OUT17/2274

**Ardmore Park Quarry (PA 07_0155 MOD 3)
Comment on the Environmental Assessment (EA)**

Figure 5 | Location of monitoring bores and springs

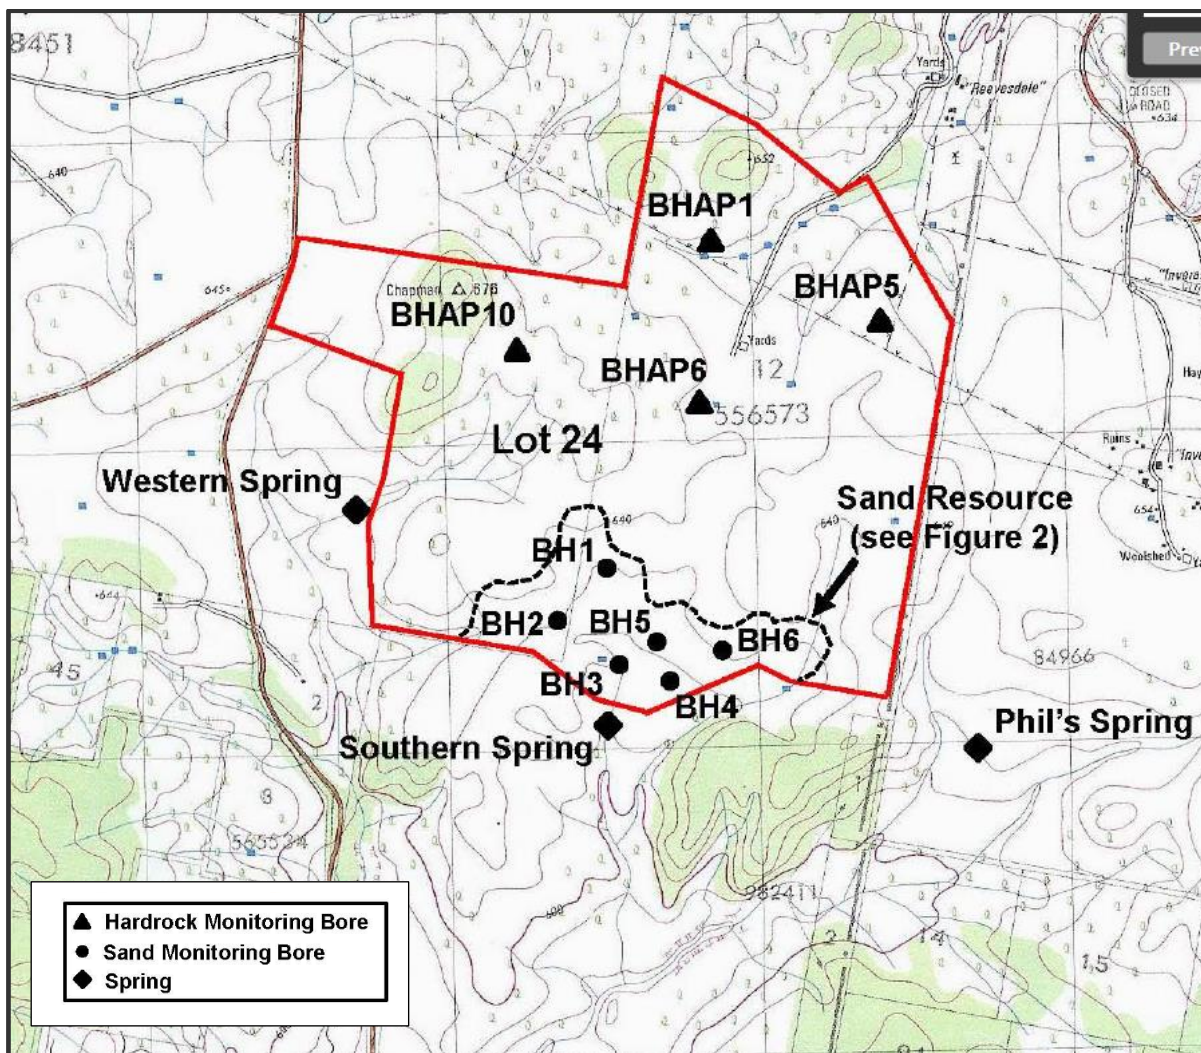
- Groundwater levels for monitoring bores are measured in three different aquifers, basalt, palaeo-alluvial, and basement sandstone. The recorded deeper basement sandstone groundwater level for BHAP6 (licence 10CA117207 – WAL30111) has a strong influence upon groundwater level surfaces if plotted all together, indicating a conical drawdown to this pumping bore. This is not considered to be representative of the groundwater levels in the aquifers of concern, the basalt and the connected underlying palaeo-alluvial aquifer at the proposed quarry extension site. There is also a notable lack of groundwater level monitoring data at the site of the basalt quarry operations and proposed extension area. The proponent should, within the next month, install a nested groundwater monitoring bore, measuring levels of groundwater in both basalt and palaeo-alluvial aquifers, immediately north of the current basalt - sand quarrying and planned extension area.

- Groundwater level monitoring bore BHAP7 is listed as “lost”. The proponent should be required to replace this bore prior to any approval being granted.
